From: Katherine Rawlins
Sent: 14 November 2011 11:01
To: [REDACTED]
Subject: BR/249/11/

I refer to the above planning application at 11 Ivydale Road, Bognor Regis, PO21 5LX for the addition of extensions and dormer windows.

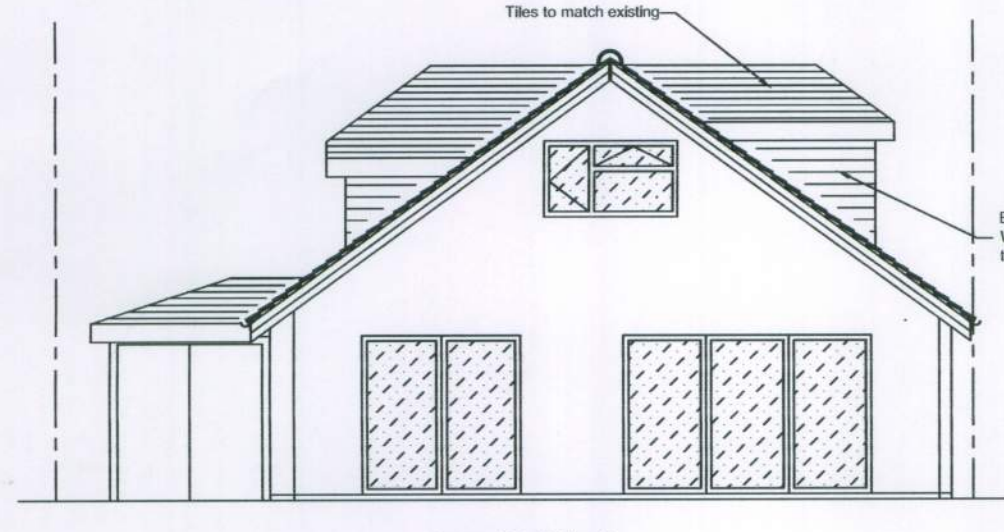
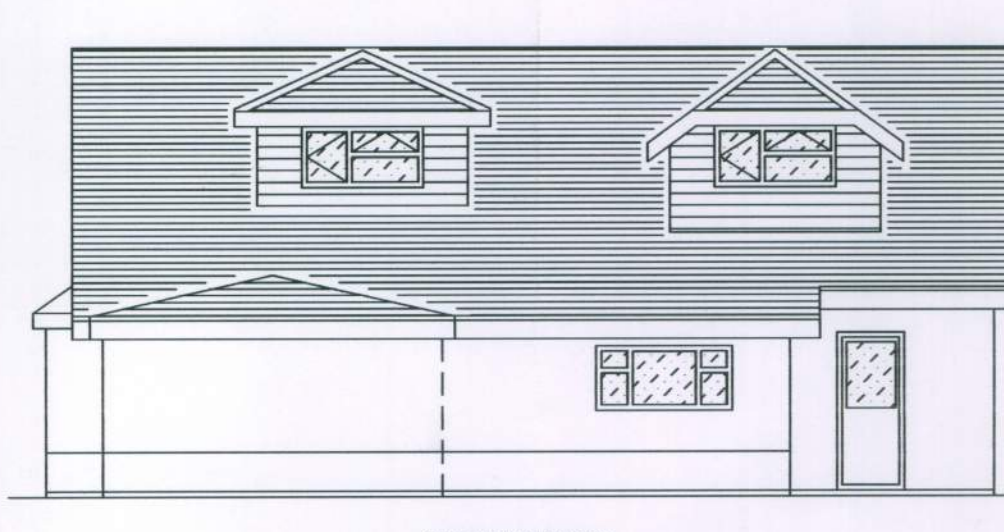
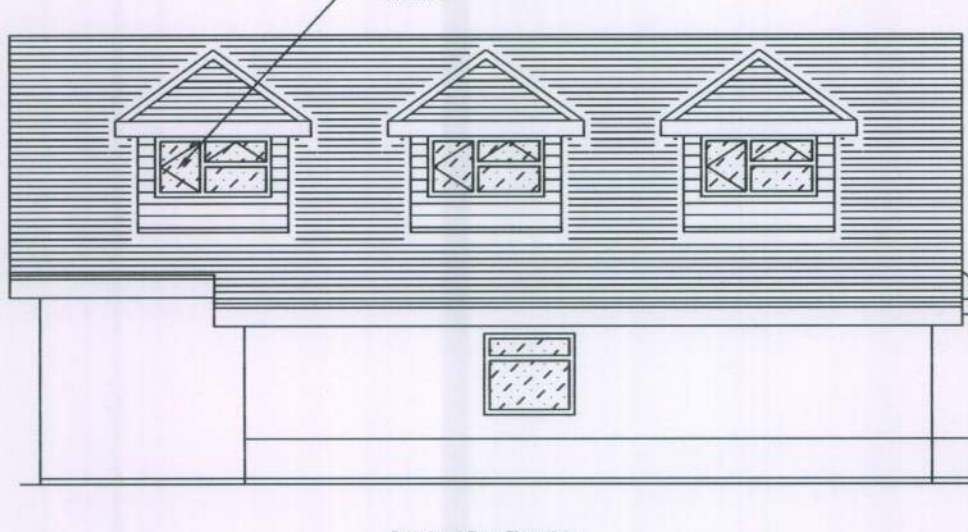
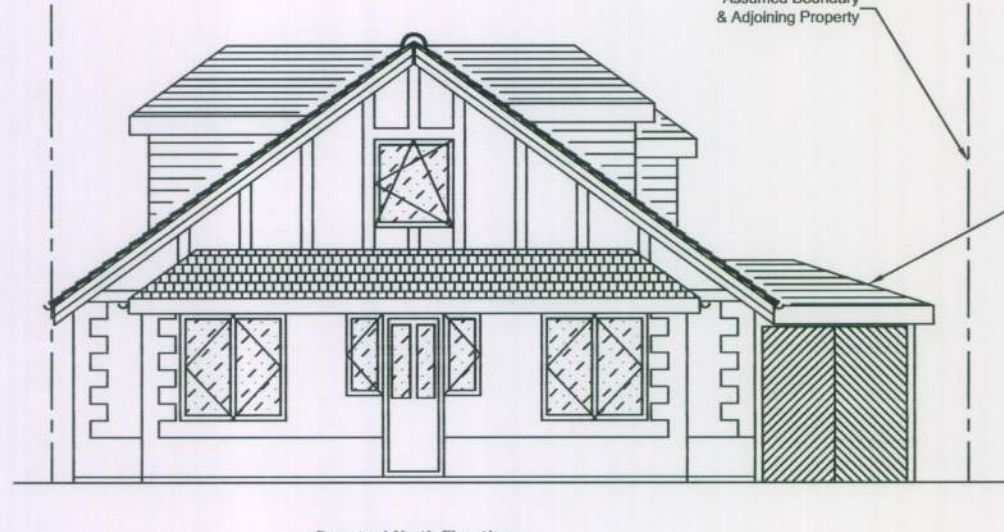
Having discussed the application with my Team Leader, the proposed front and rear extensions, and the addition of dormer windows are considered acceptable in design and visual amenity terms. However, the proposed side extension with a hipped roof adds significant bulk and massing to the property and is considered unacceptable in design terms. From the submitted floorplans the garage at ground floor level is extremely narrow in width and would be unable to accommodate a car.

Please could you therefore amend the drawings by omitting the side extension and inserting an additional hipped roof dormer window on the west facing roofslope. On receipt of amended plans, the officer recommendation will be to approve the application.
